**Yass Valley Wind Farm Visual Impact Assessment,
Review of Adequacy**

Prepared By: Dr Richard Lamb

Prepared For: The NSW Department of Planning and Infrastructure

September 10, 2014

Viewpoint CVP4

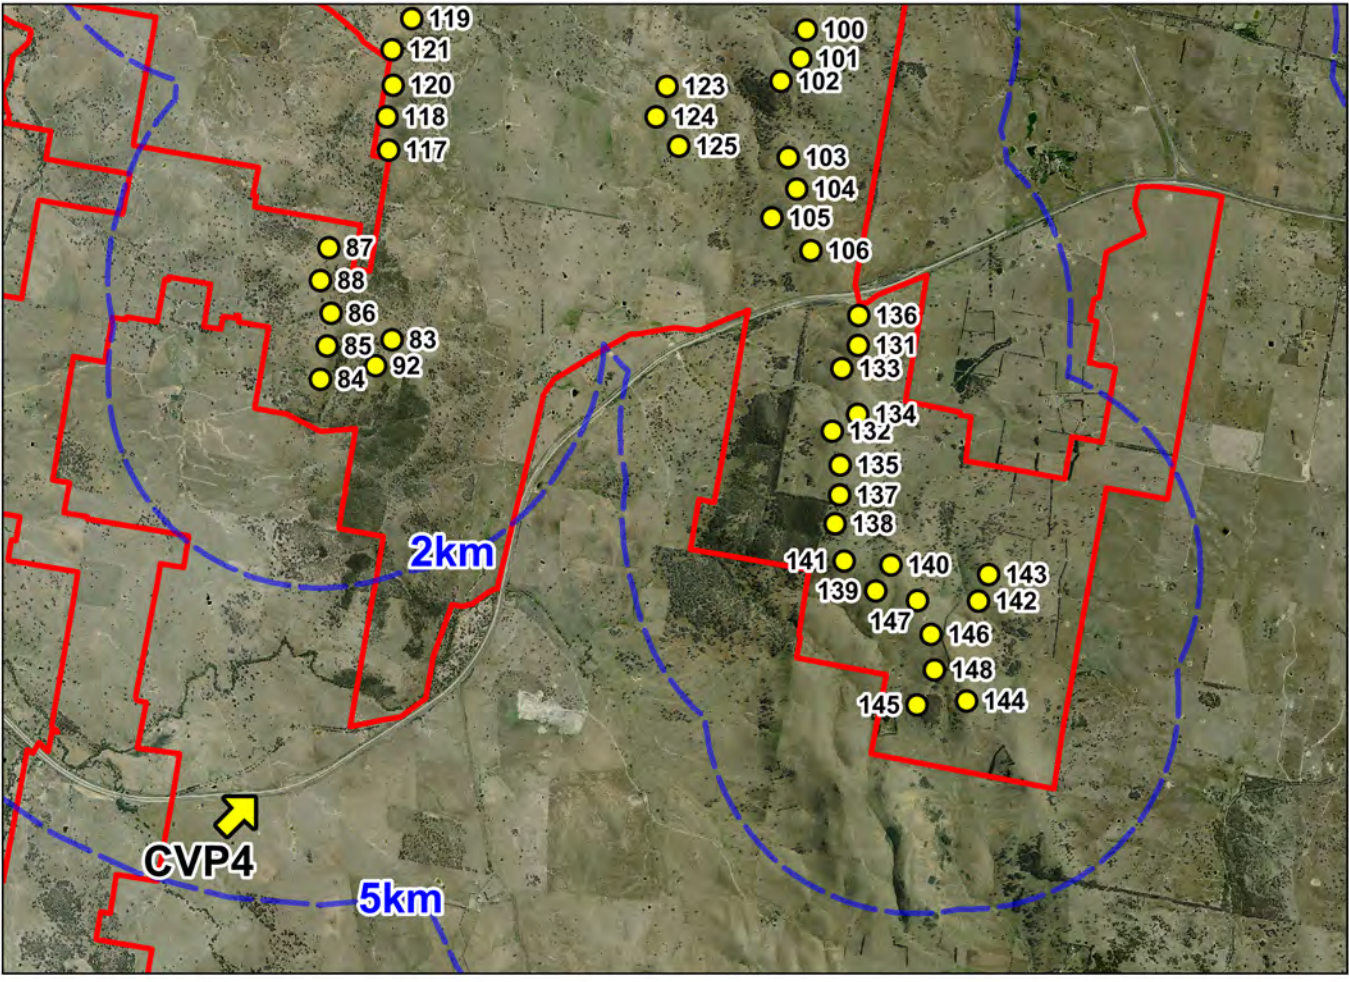
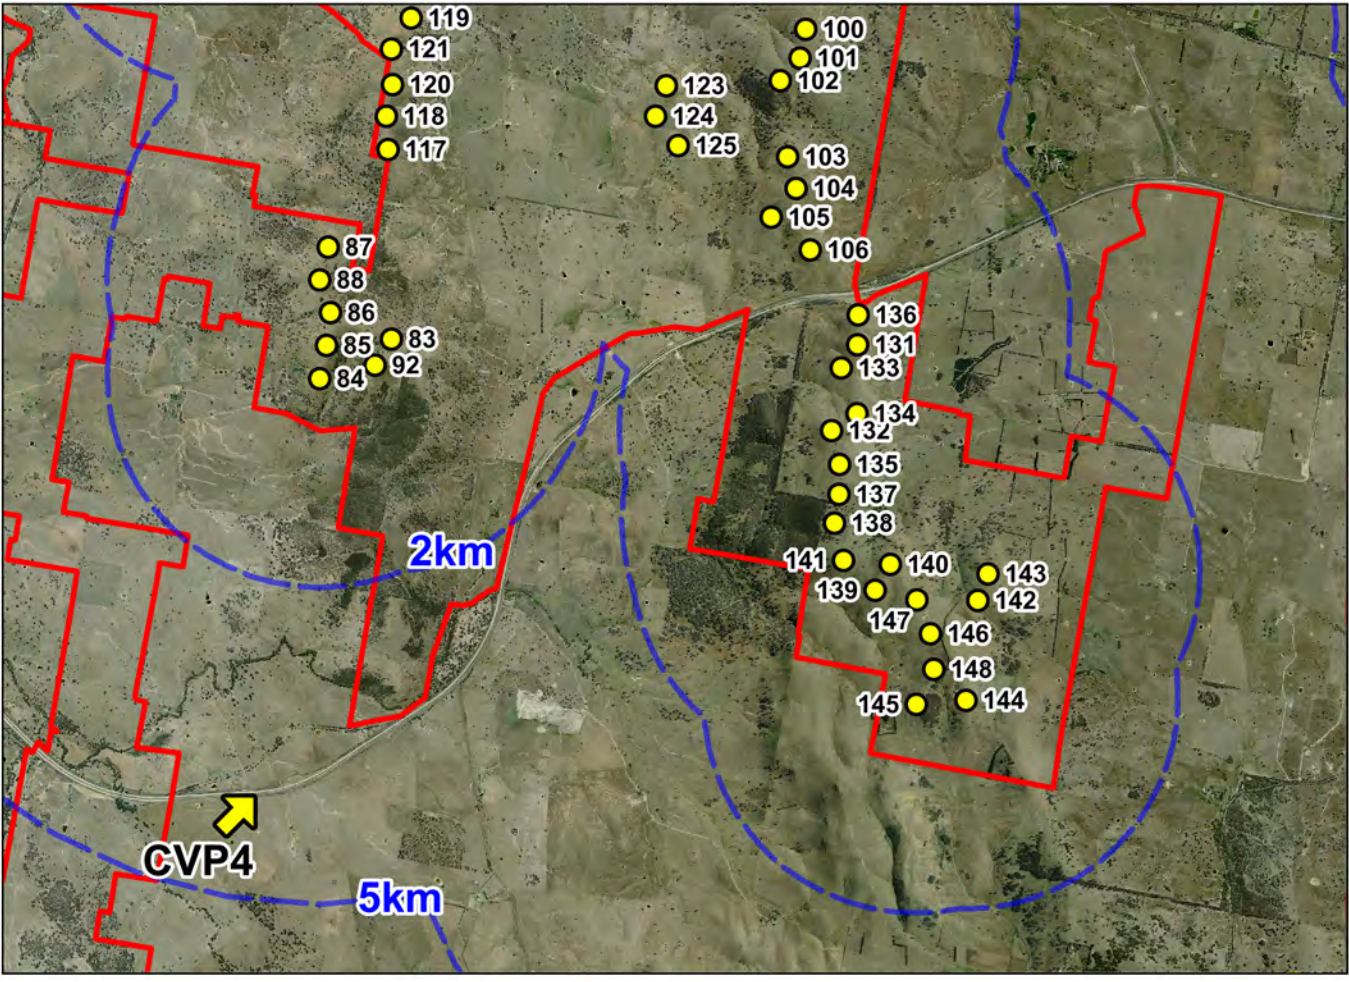
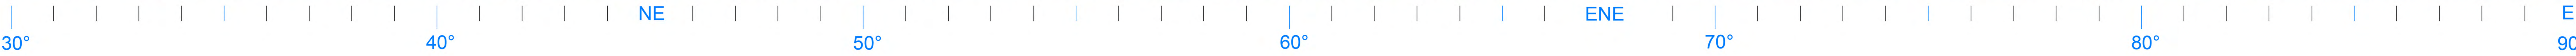
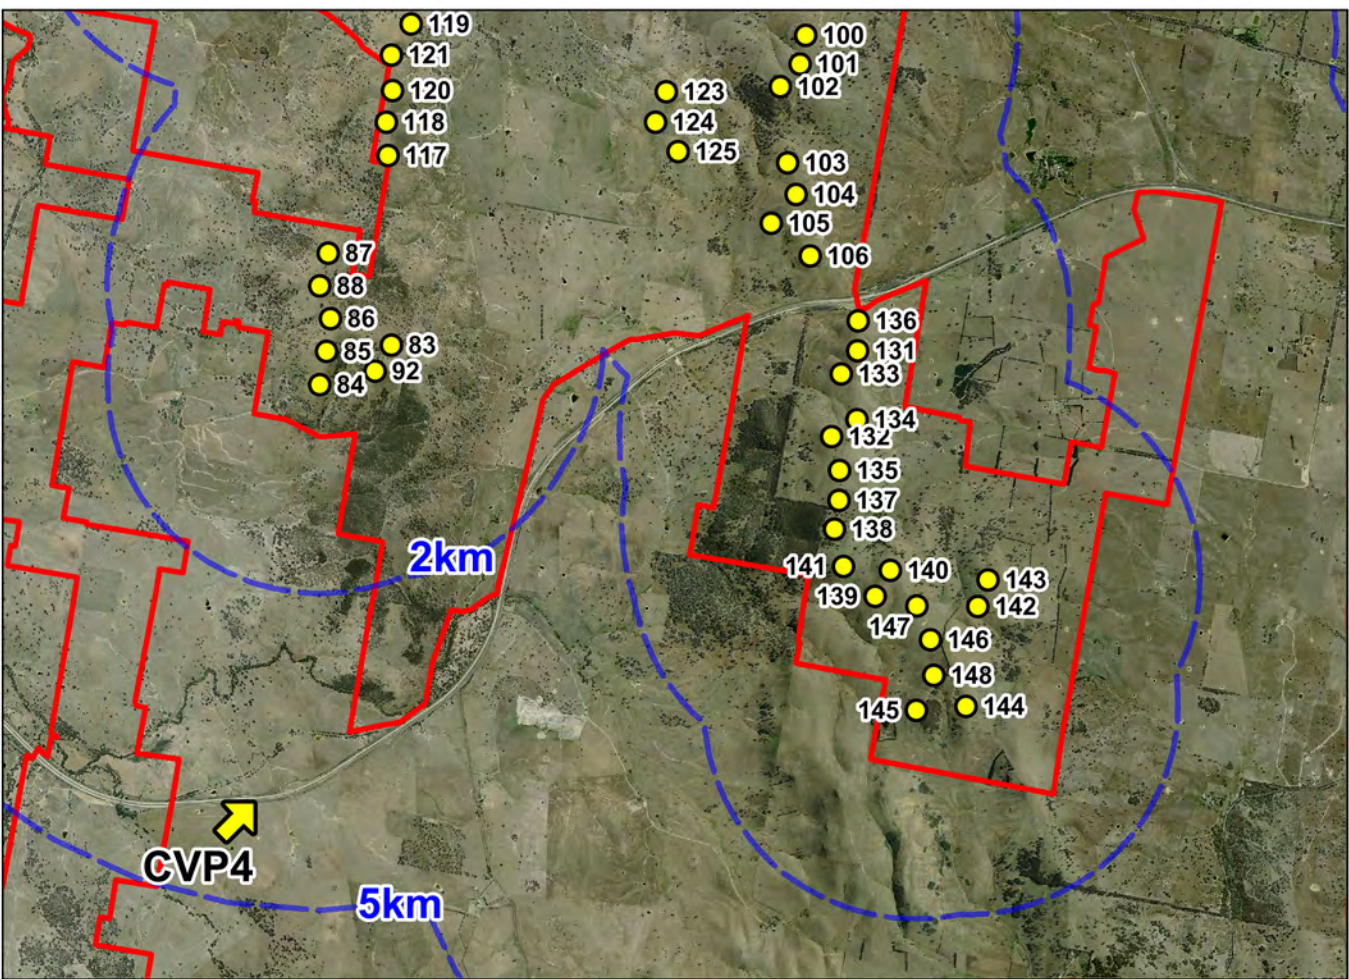
Though turbines are generally located in LU2 and LU1 they may be seen, as demonstrated in photomontages, in the context of LU3 (typically steep forested hills, eg. montage CPV4 or LU4 (high sensitivity areas including rural townships or public places, eg. montage SVP3 and 4). A summary table 7.2 at page 84 of the LVA states that 29 of the 34 public viewing locations assessed are either LU1 or LU2 and have an overall visual impact rating of either nil, minor or medium. The authors assert that this is because the majority of the surrounding landscape has been found to be of medium level of sensitivity and that viewers are further away and limited in number.
